An
Bord
Pleanála

Inspector's Report

ABP-315173-22

Construction of a rockfill and earthen reinforcement buttress to sections of the extant embankment wall of the Tailings Storage Facility. An Environmental Report and a Natura Impact Statement (NIS) were received with this application.

Drawing 3.12: Buttress Typical Sections

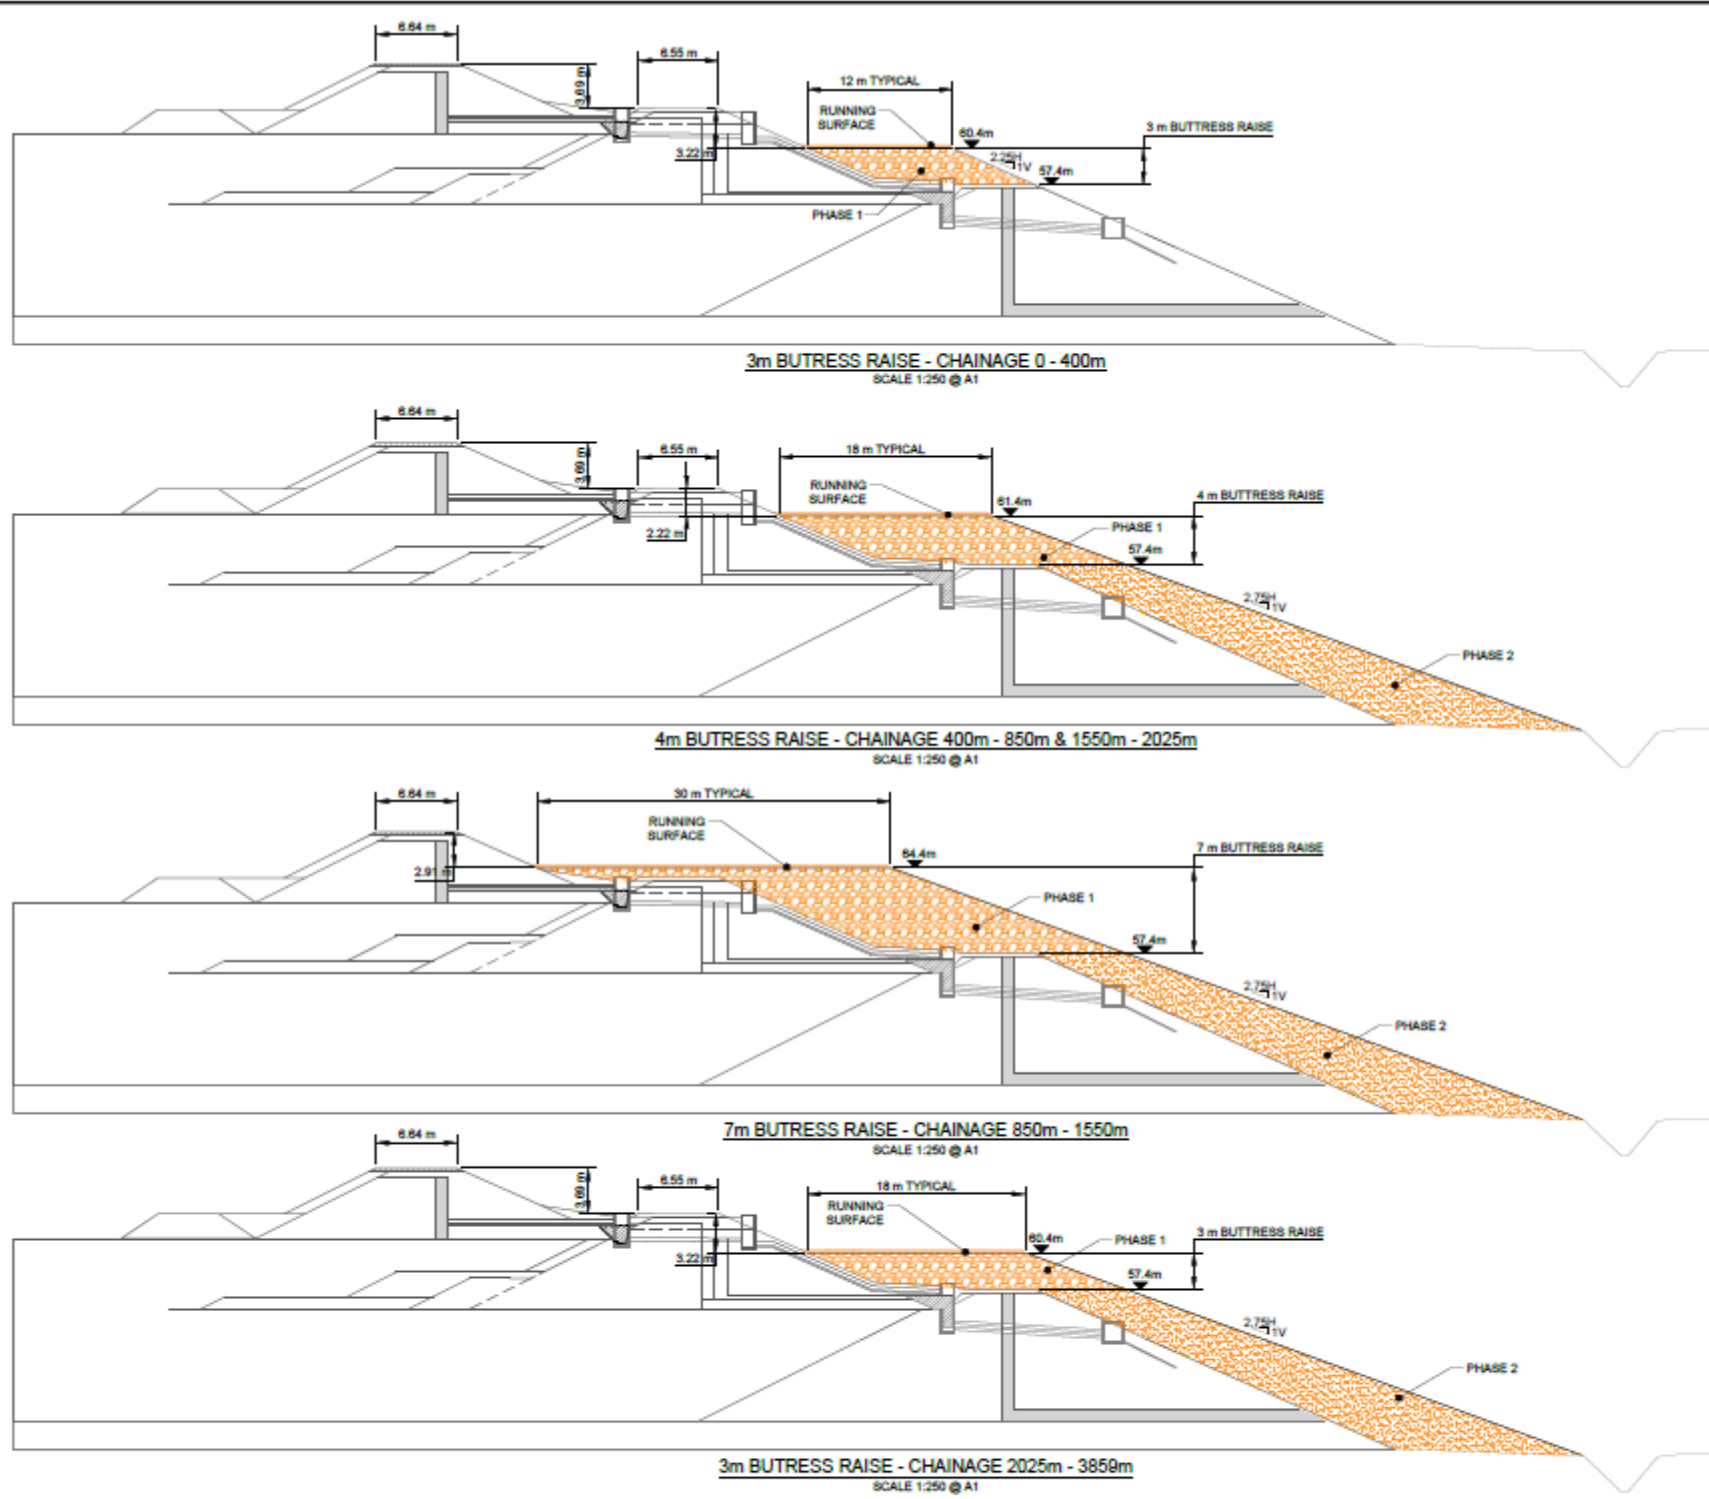
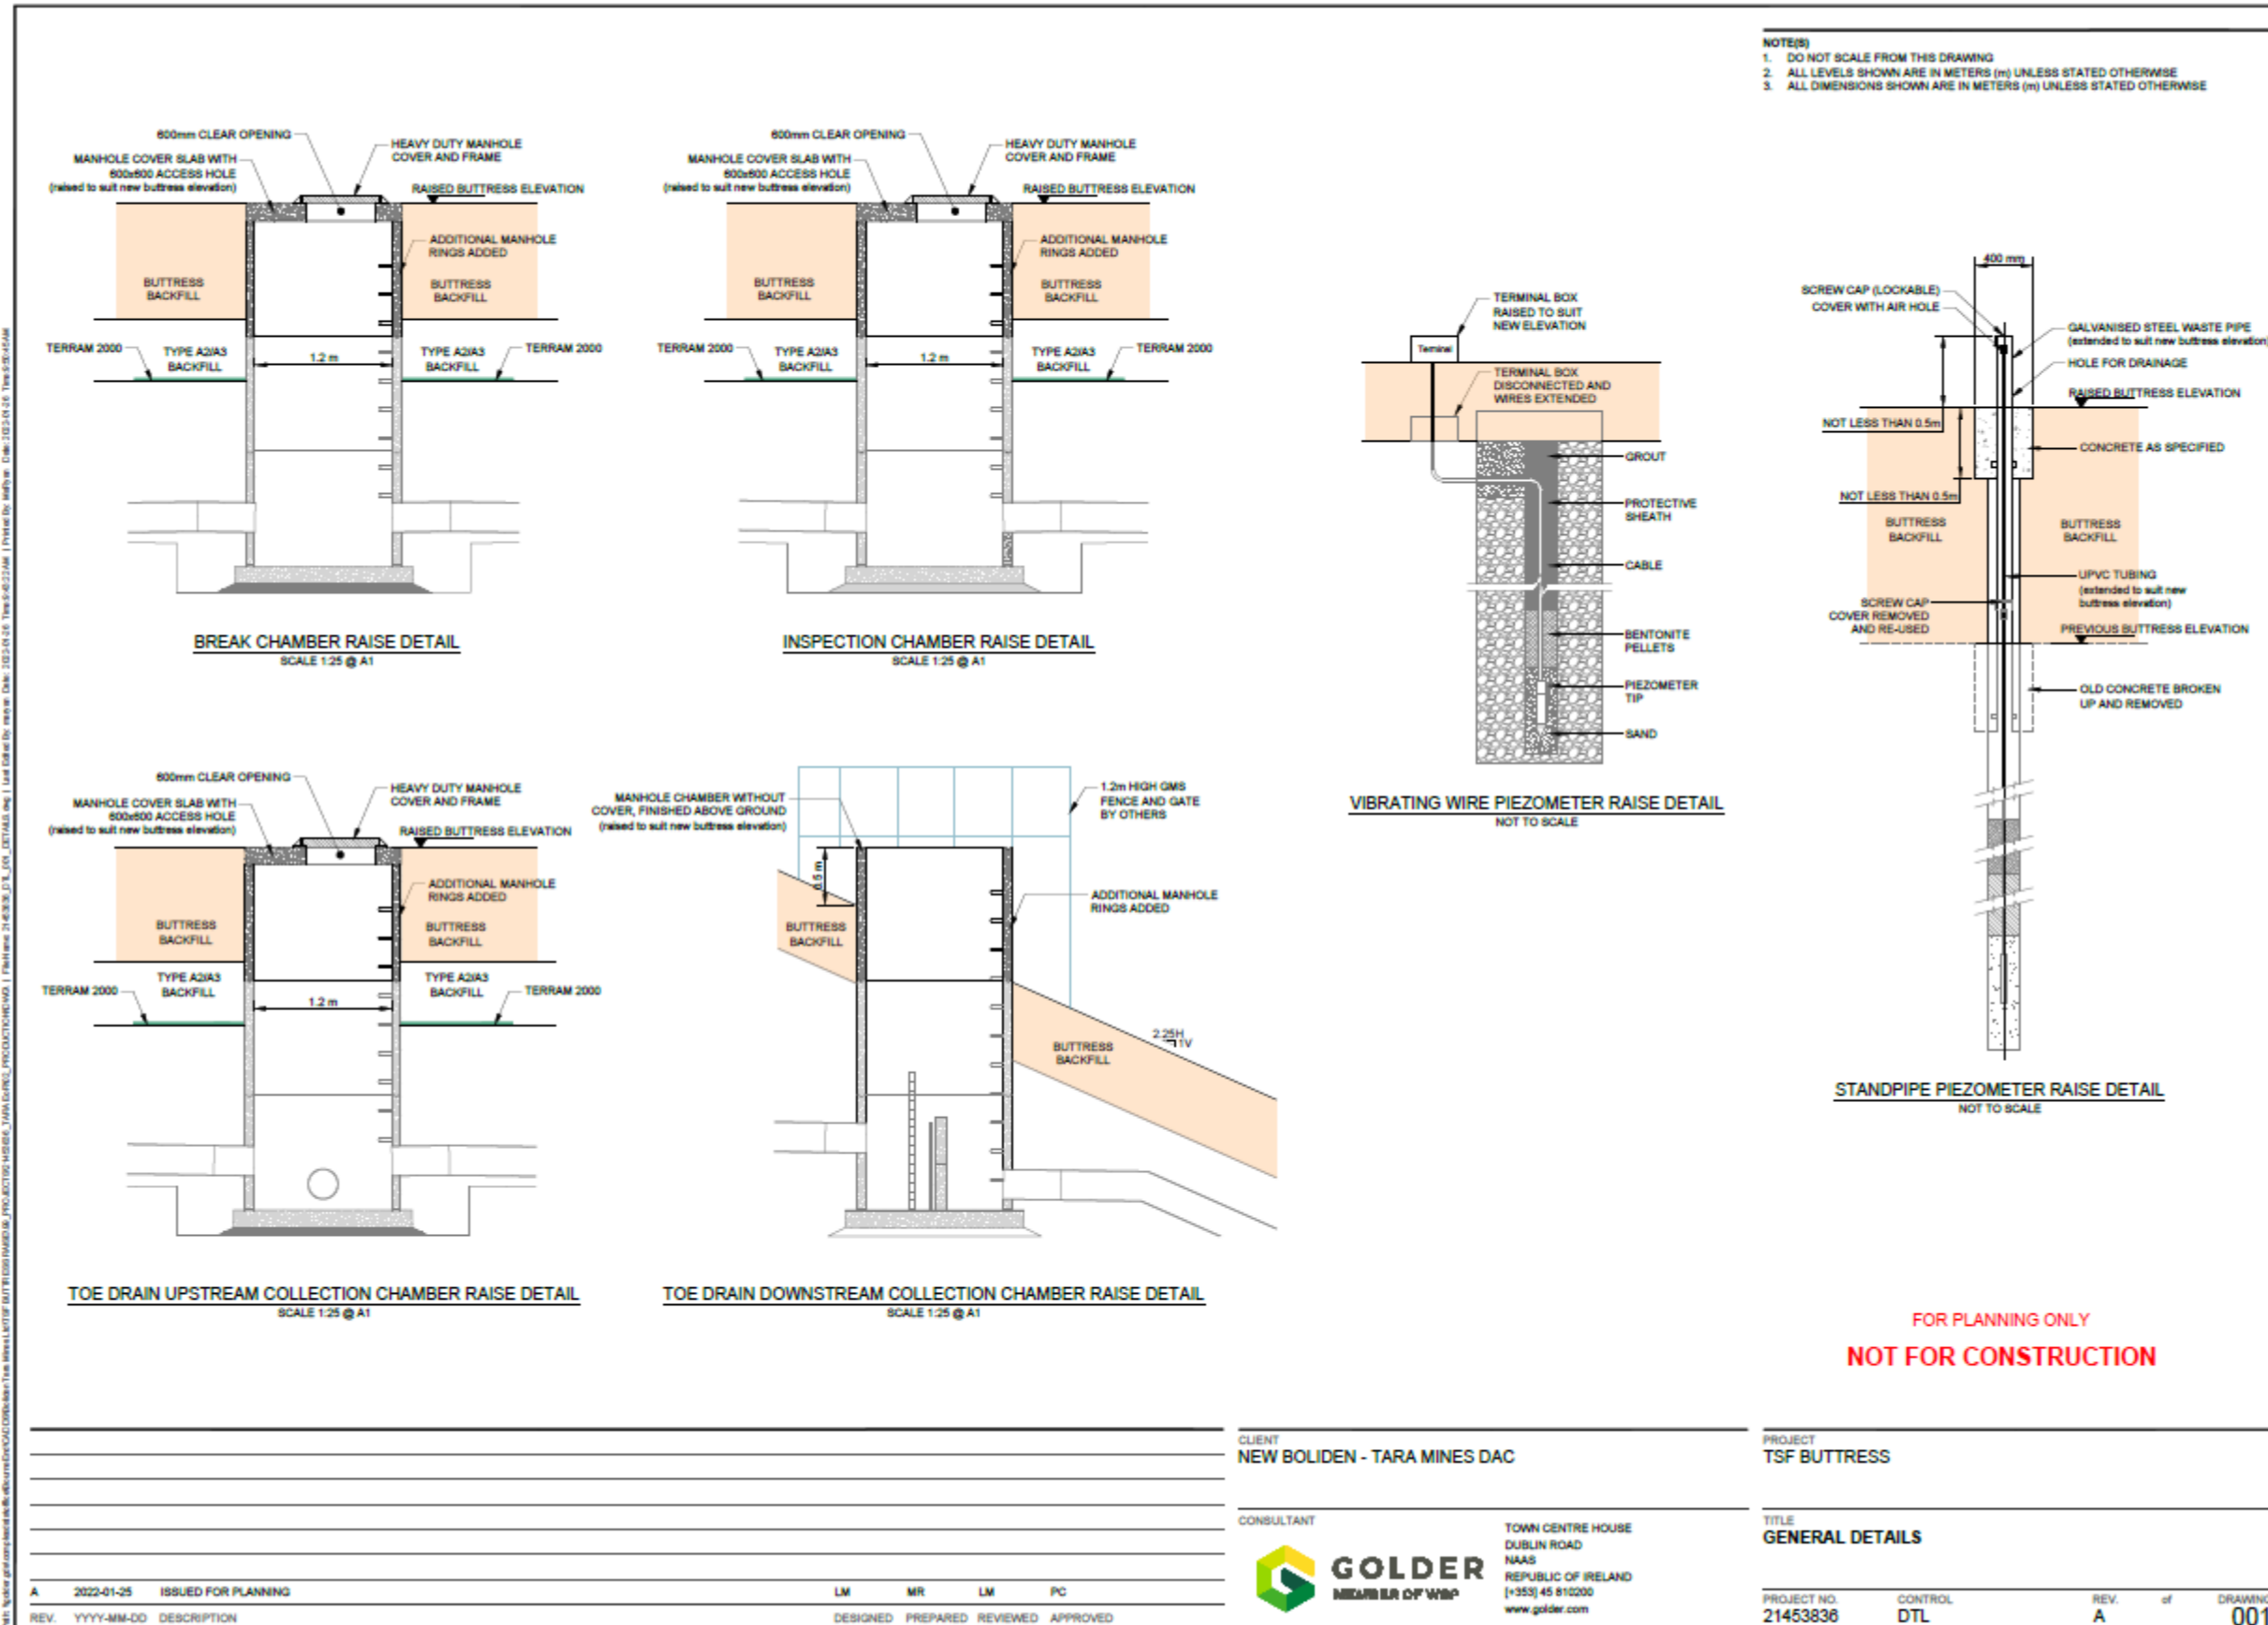
- Legal cases have established the criteria for the scientific approach to AA Assessment.
- The drawings are inadequate as the sections do not show bedrock, subsoil and where the deposited material starts. This is contrary to the Balscadden case where it was found that structures have to be shown.

- Section drawings are required to be at a maximum scale of 1:200 in the Planning and Development Regulations, 2001, as amended. The section drawings submitted are 1:250. The overall height of the dam walls are not shown on the sections.
